Appeal Decision

Appeal Ref: APP/Z4718/D/25/3373575

4 South View, Savile Town, Kirklees, Dewsbury WF12 9LE

- The appeal is made under section 78 of the Town and Country Planning Act 1990 (as amended) against a refusal to grant planning permission.
 - The appeal is made by Mr Liaqat Ali against the decision of Kirklees Metropolitan Council.
 - The application Ref is 2025/62/91341/E.
 - The development proposed is proposed second floor extension.
-

**PROPOSED REAR ELEVATION  
(North West)**

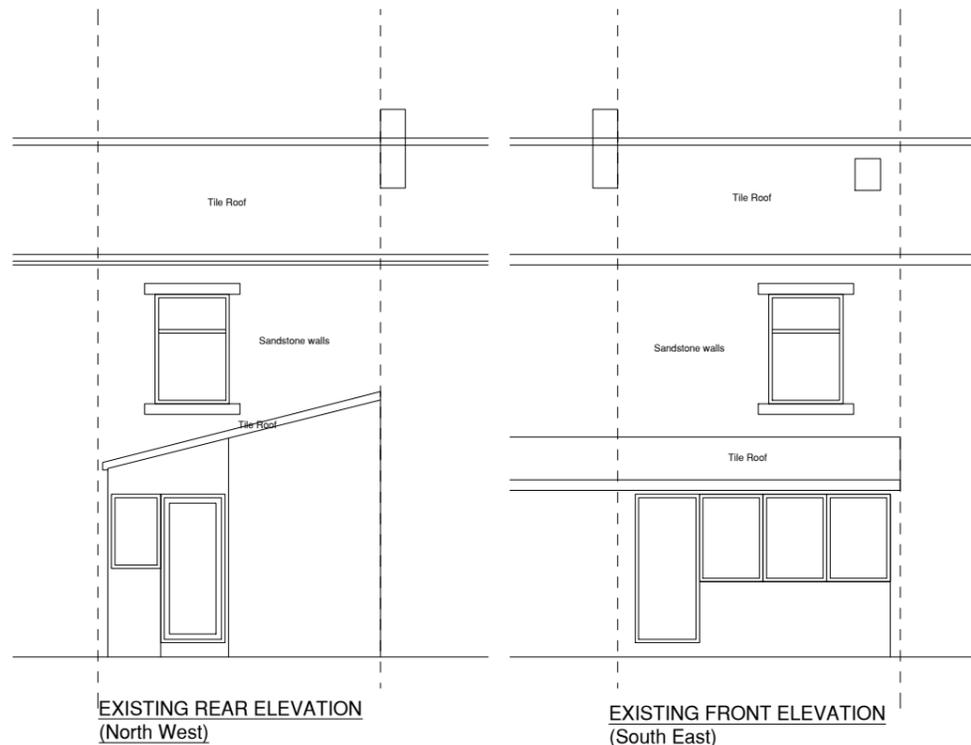
4. The proposed development would raise the roof on the appeal property to add a third storey. The materials would match the existing stonework, and the windows would be in line with those on the first floor. I appreciate that of the 16 houses in the terrace only 4 have been similarly extended, but in the context of similar extensions within the area, and in particular the immediate street scene that I have described, the proposed development would not be out of keeping.
5. Overall, I conclude that the proposed development would not conflict with Policy LP24 of the Kirklees Local Plan (2019), Key Design Principles 1 and 2 of the House Extensions & Alterations Supplementary Planning Document (2021) and section 12 of the National Planning Policy Framework (2024) which require development to respect the character of the townscape and be in keeping with existing buildings.
